**DELEGATED DECISION TO DETERMINE PLANNING APPLICATIONS**

Reference No:	<b>2025/62/92829/W</b>
Site Address:	58, Dalton Green Lane, Dalton, Huddersfield, HD5 9UH
Description:	Removal of existing garage and erection of two storey side and single storey rear extensions, widening of vehicular access, extended dropped kerb and associated alterations
Recommending Officer:	Joanna Rednall

**DECISION – CONDITIONAL FULL PERMISSION**

south west elevation

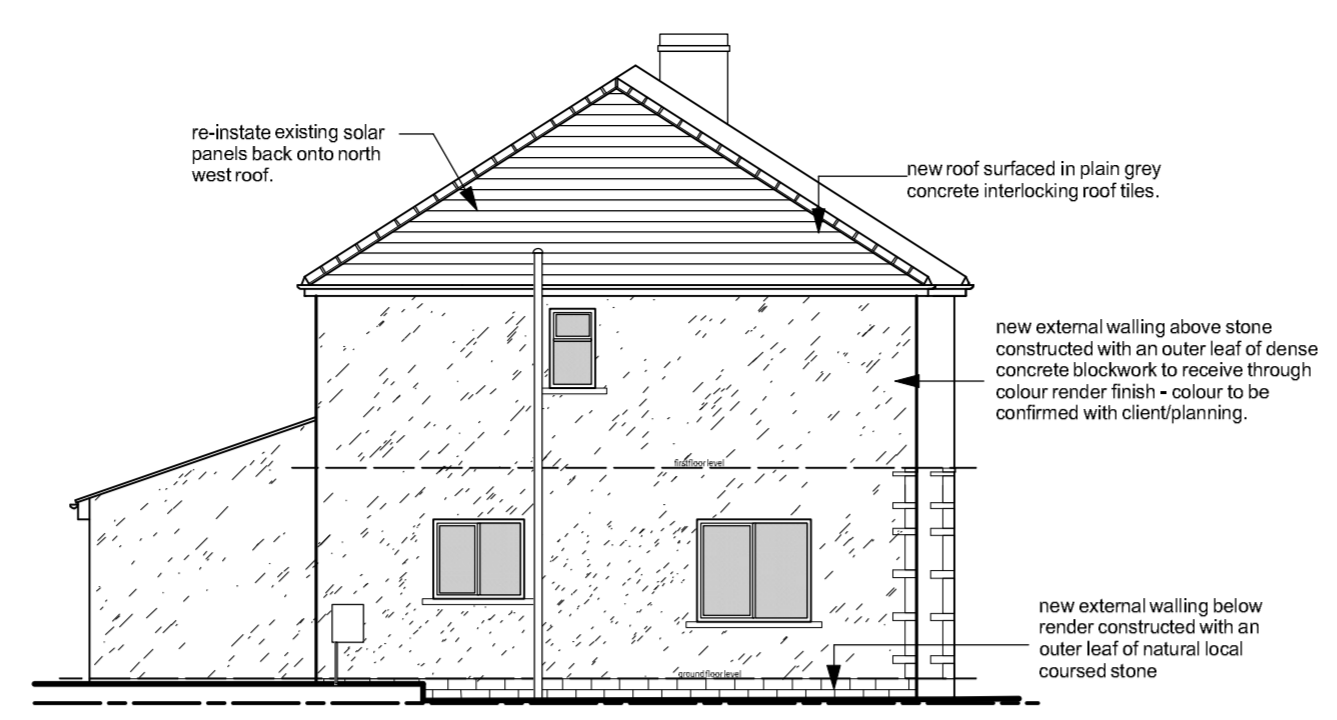
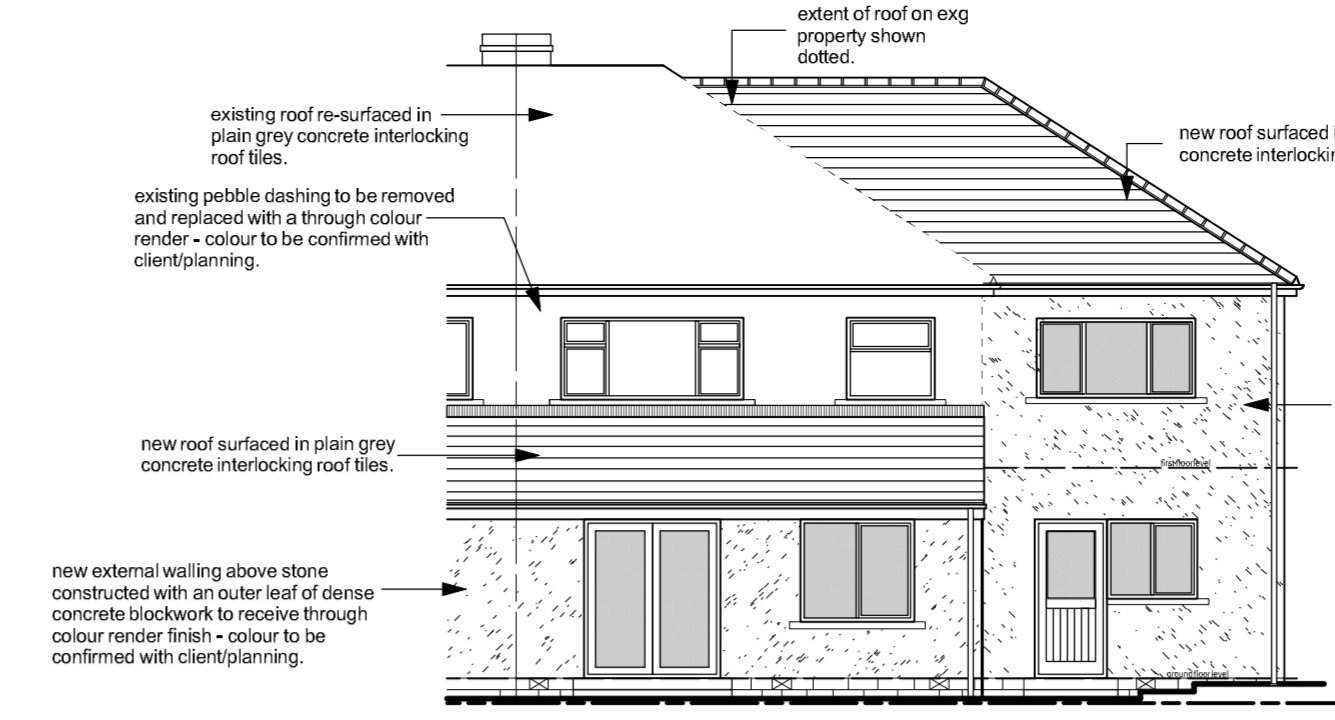
3. The materials of construction of the ground floor front (south west) elevation wall shall be local coursed stone to match the existing dwelling in the location indicated upon submitted drawing 2025/052/03revA. All areas annotated to be render to the first floor front (south west), side (north west) and rear (north east) wall elevations upon submitted drawing 2025/052/03revA shall be of a stone or cream colour finish. The materials of construction of the roofs of the development hereby approved shall be of a dark grey colour finish.

Revisions:
Rev.A (01-12-2025) - 3no. off road parking spaces illustrated on drg.
Rev.B
Rev.C
Rev.D
Rev.E

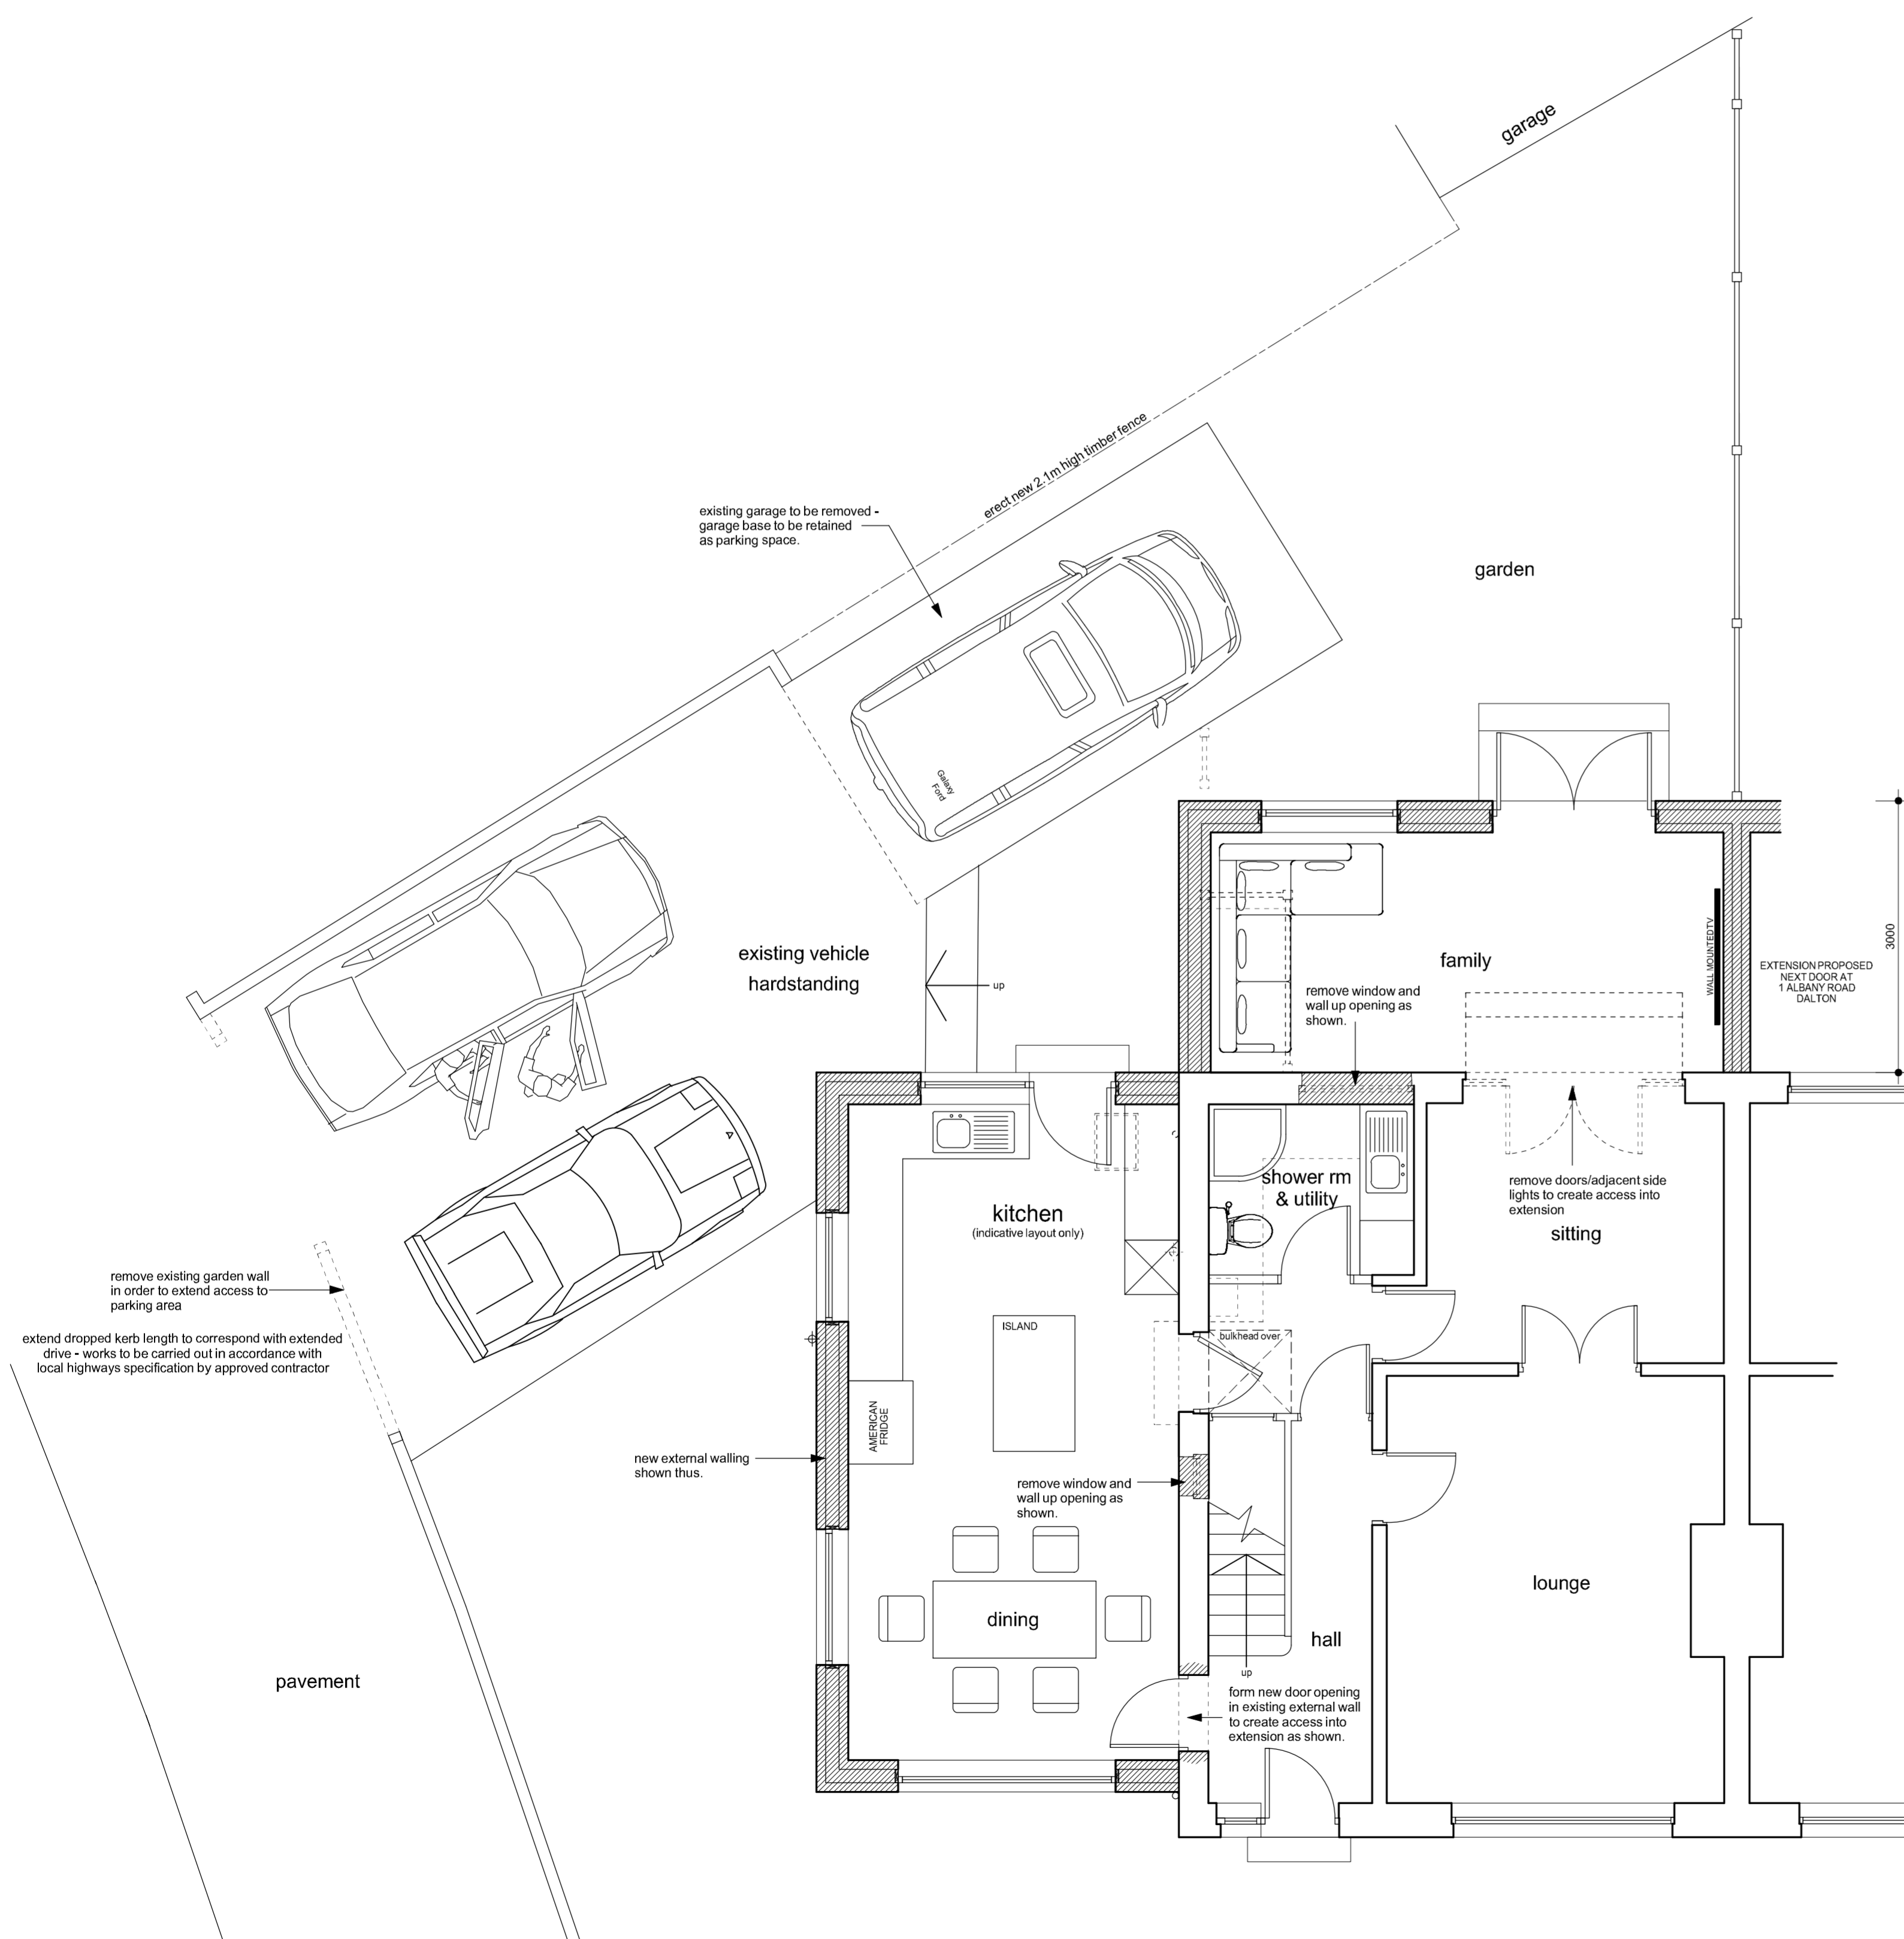
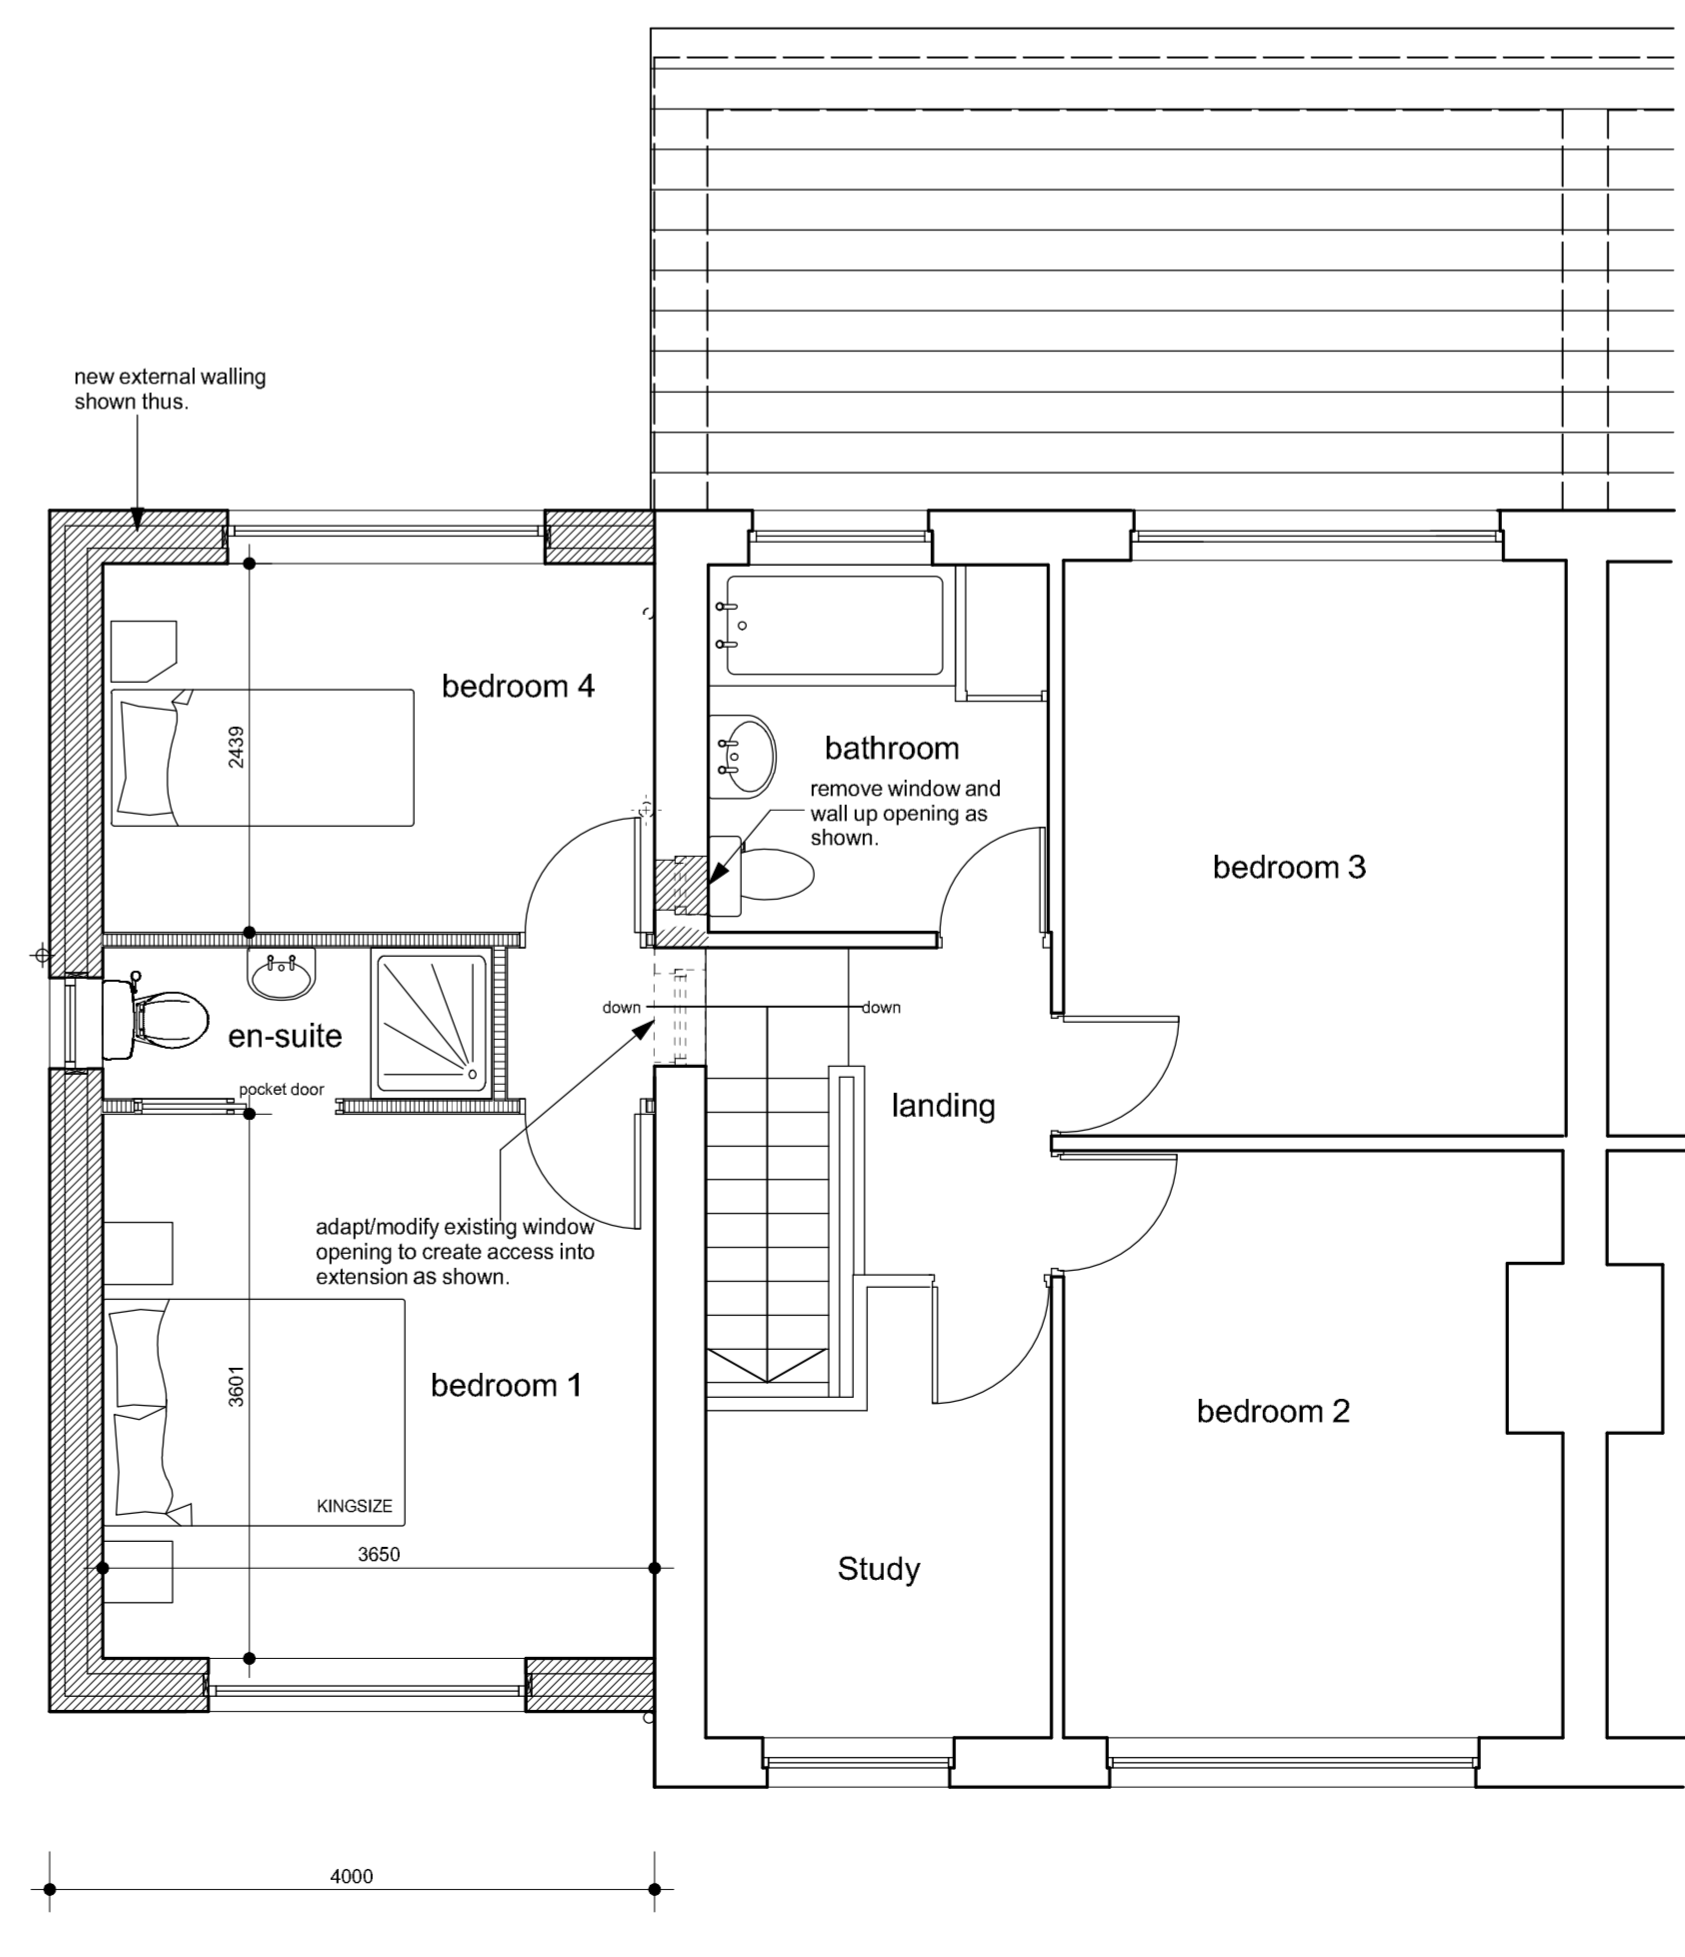
After consulting with KC Highways Development Management, officers requested a proposed site plan to confirm that the scheme can accommodate 3 off-street, in-curtilage parking spaces. Amended plans were received on 1<sup>st</sup> December 2025 which were considered to address the concerns raised by Highways.

The proposed development would increase the total number of bedrooms on site, taking the total number of bedrooms from 3 to 4. KC Highways were consulted on the scheme and requested a proposed site plan showing whether the proposal could accommodate 3 off-street parking spaces, in accordance with the requirements of KDP 15 of the SPD. Amended plans were submitted showing the required information which were considered acceptable from a highways safety perspective.
